Recommendation Report for Planning Permission for Works or Extension to a Dwelling

REF NO: BE/76/18/HH

LOCATION: 1 Old Moat Close
Bersted
PO22 9UP

PROPOSAL: Single storey rear extension with pitched tiled roof (resubmission following BE/9/18/HH). This application affects the character & appearance of the Shripney Conservation Area.

Proposed South West Elevation

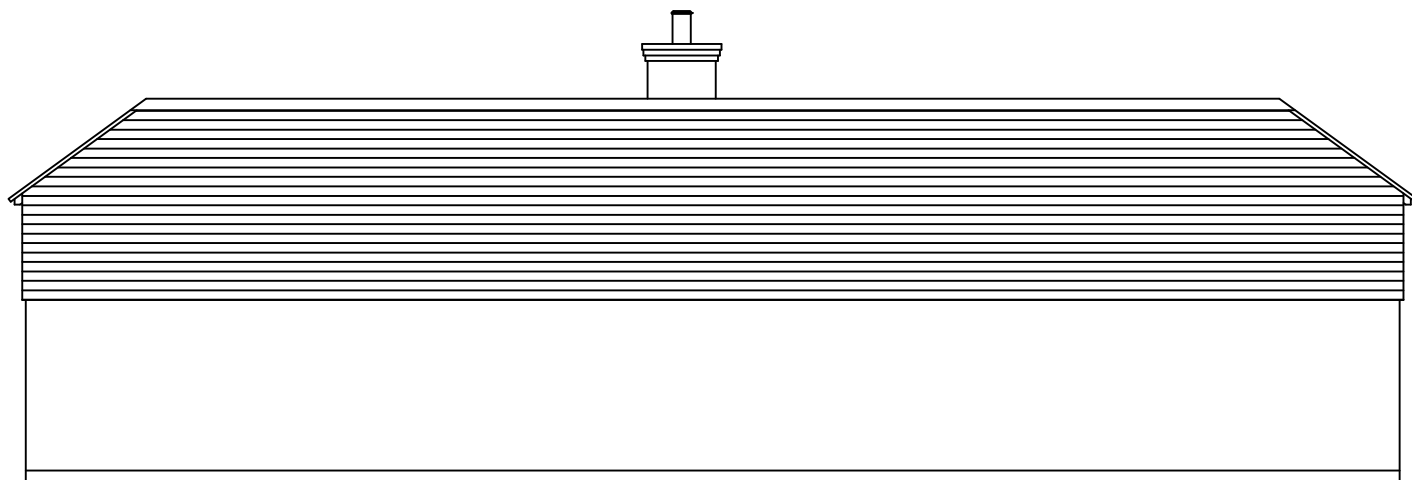
It is considered that the proposed extension provides the opportunity to improve living accommodation, whilst also being simple in appearance. The new window/door design should respect those already present in order to ensure that the existing character is maintained. In addition, I note that two rooflights are proposed. Whilst these are acceptable, they should be of a conservation standard design. Details of the windows/doors/rooflights should be provided for by way of condition.

The proposed extension is subservient to and will visually integrate with the existing building. Furthermore, the only impact on the amenity of no. 2 Old Moat Close is a loss of light to the top half of an existing secondary window and this is not considered to be materially harmful to the living conditions of the neighbouring property.

- 2 No development above damp proof course (DPC) level shall take place unless and until a schedule of materials and finishes to be used for external walls, roofs and windows and doors of the proposed extension have been submitted to and approved by the Local Planning Authority and the materials so approved shall be used in the construction of the extension.
